# ENG-CDR21014-R2-DR.pdf Markup Summary

① DROP STRUCTURE (#1, #3) - PLAN VIEW  
 SCALE: 1"=5'

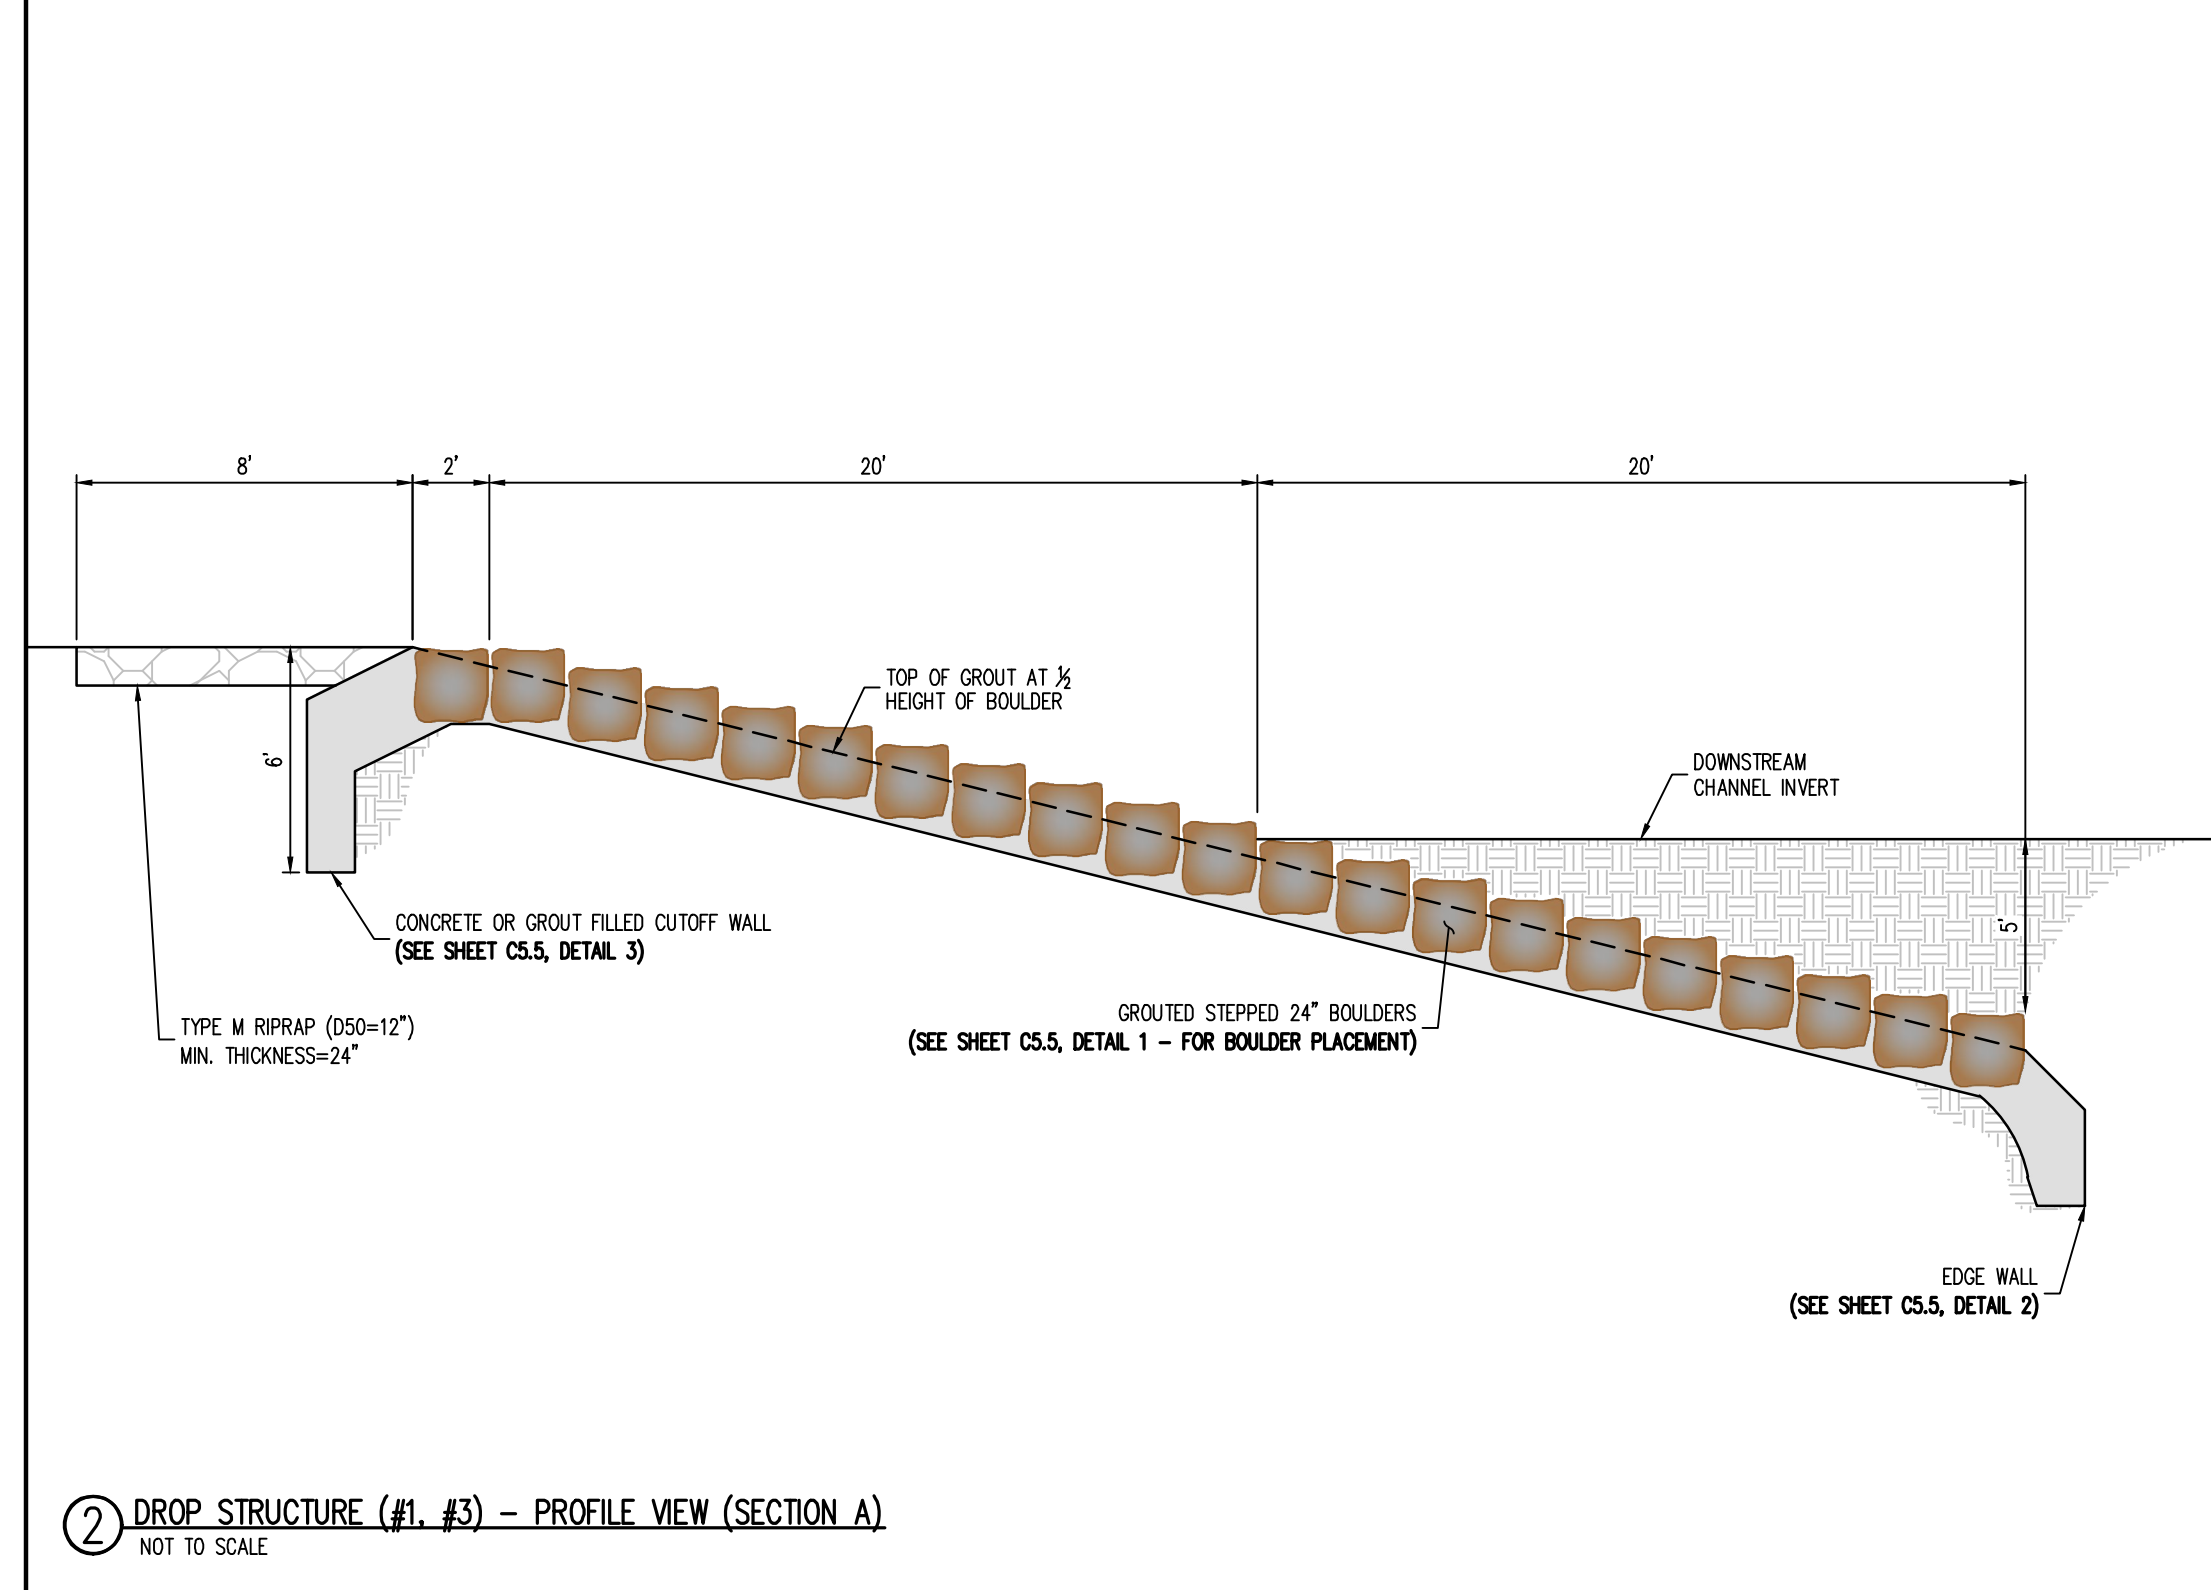
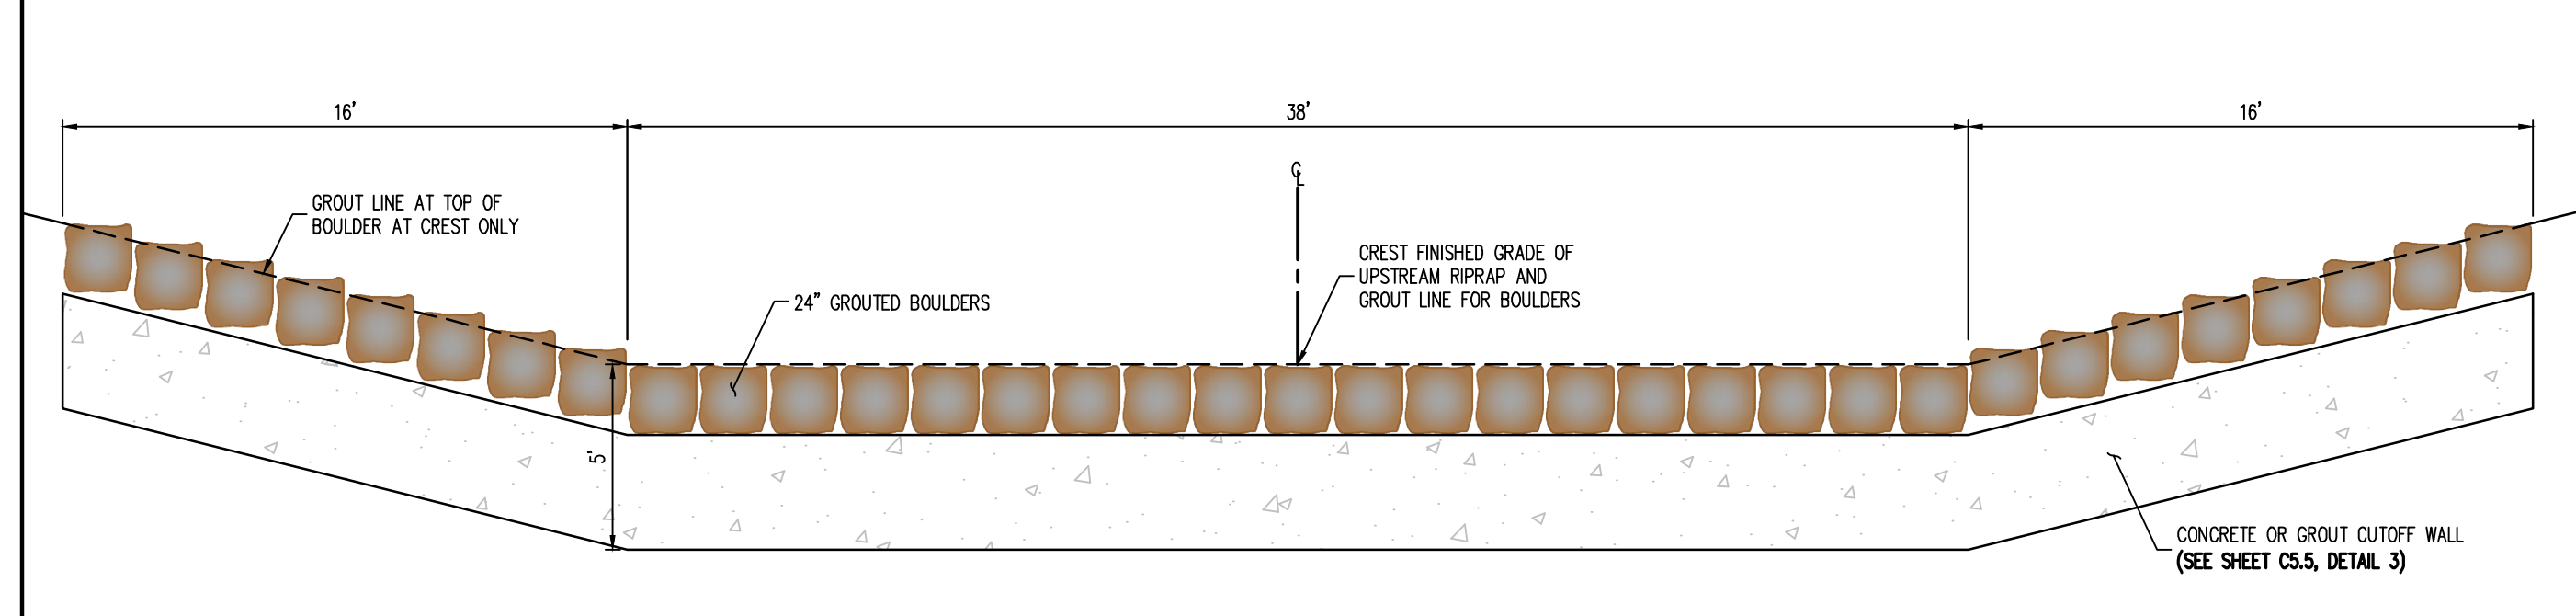
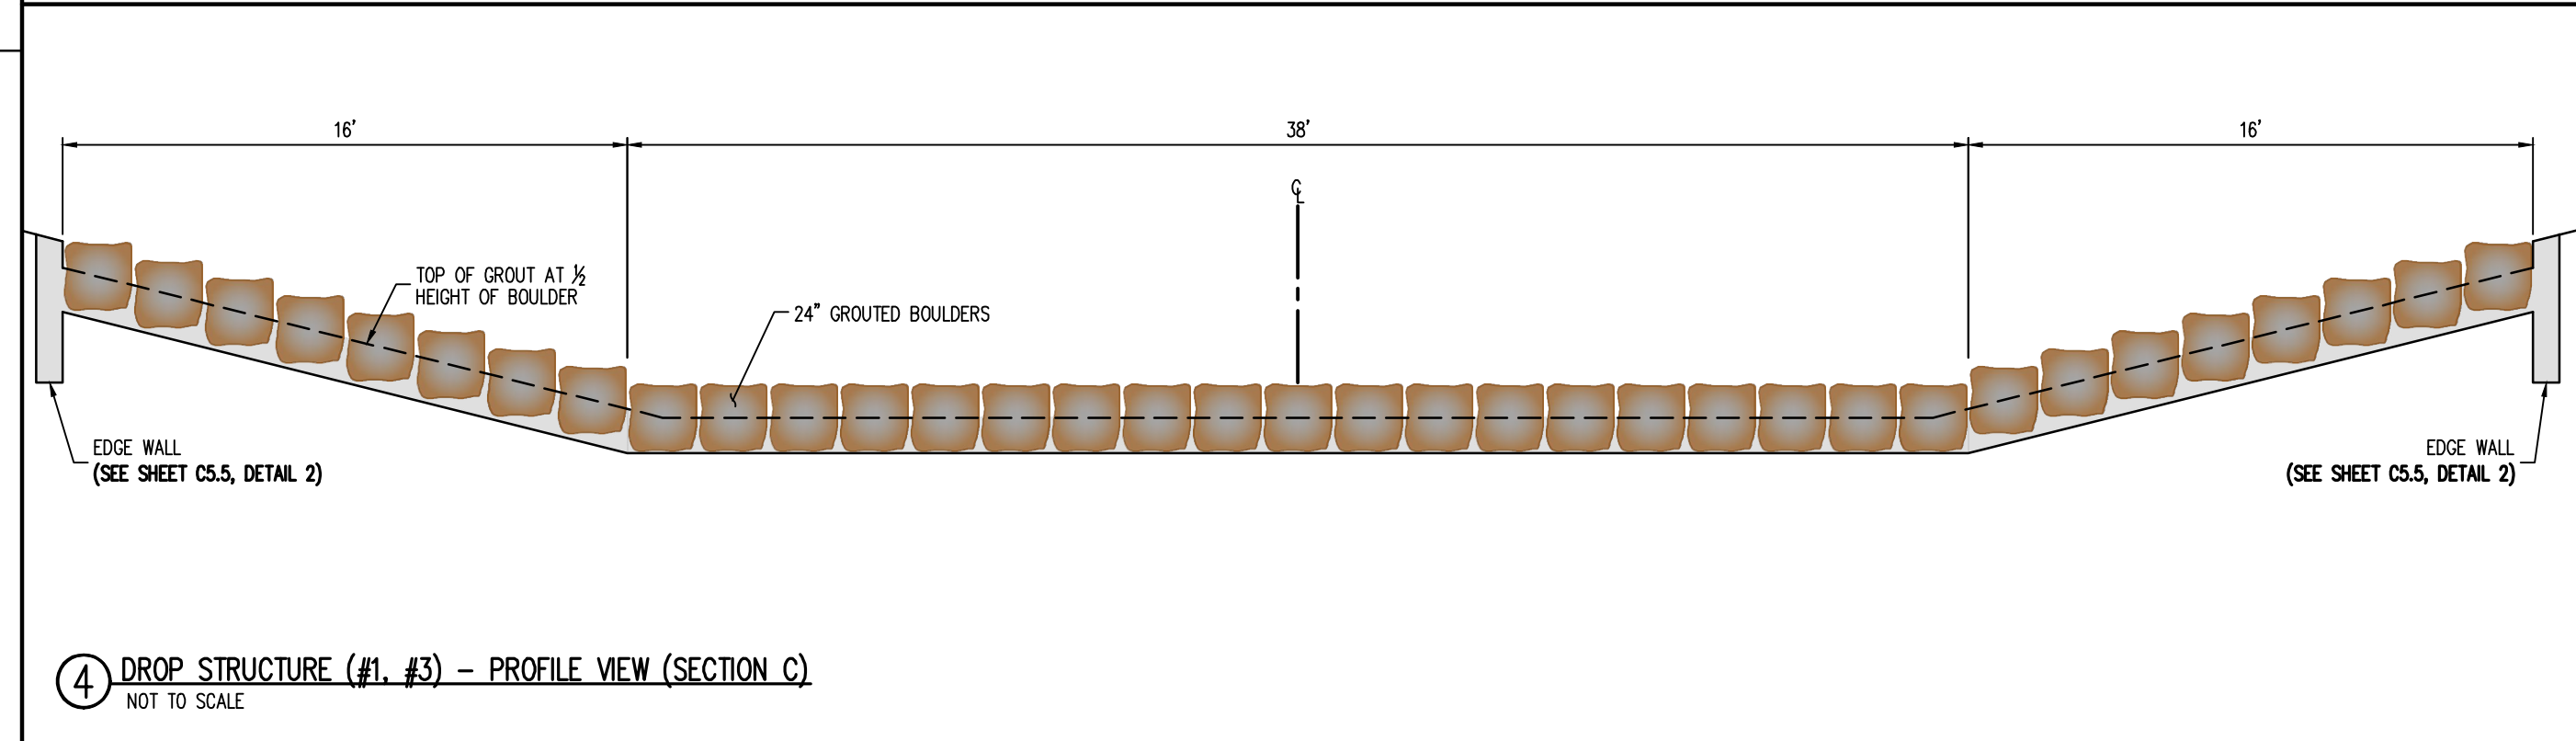
Provide cross-sections at the 3 drop structures similar to upstream drops
